From:
Sent: 19 December 2025 10:42
To: DC Admin
Subject: Comments re Planning Application 2025/62/93041 Land Adj, 2, Hopton Hall Lane, Upper Hopton, Mirfield, WF14 8EP

3 Fairways
Upper Hopton
Mirfield
W Yorks

GROUND FLOOR PLAN  
1:100

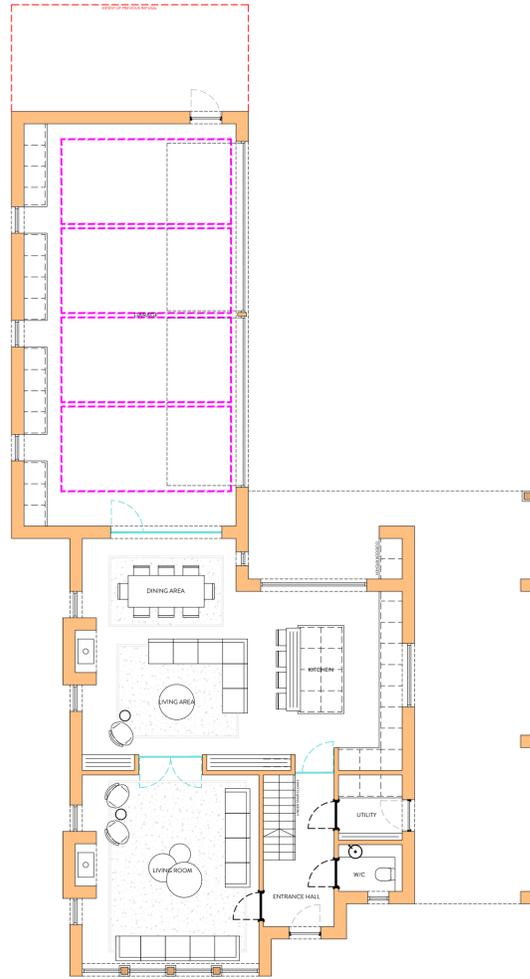
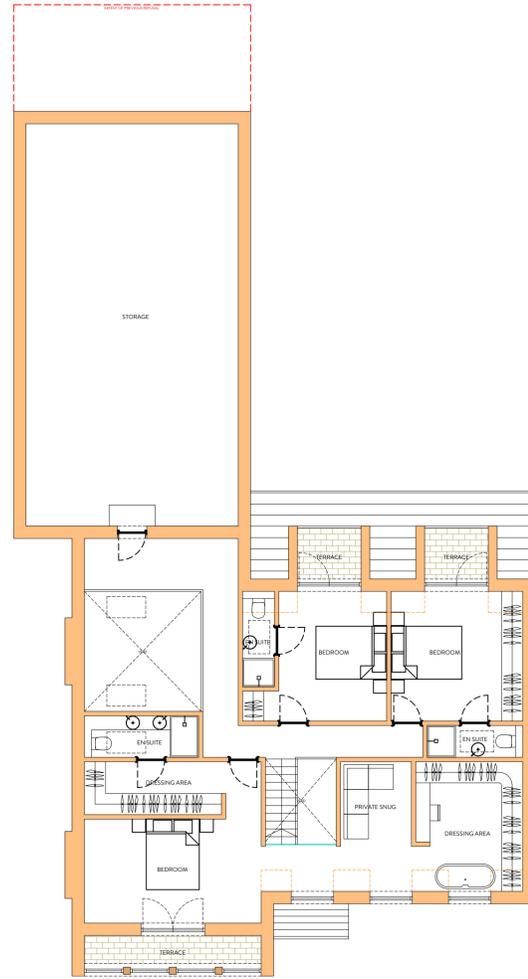
1. The revised proposal is still a large overbearing development which is out of character with the surrounding properties.
2. The revised proposal is no further away from our boundary than the previous submission. It is still approximately 1m from our boundary at the closest point.
We note that the plot of land has increased in size northwards from the previous submissions. There is therefore certainly scope to build this property further to the north away from our boundary.
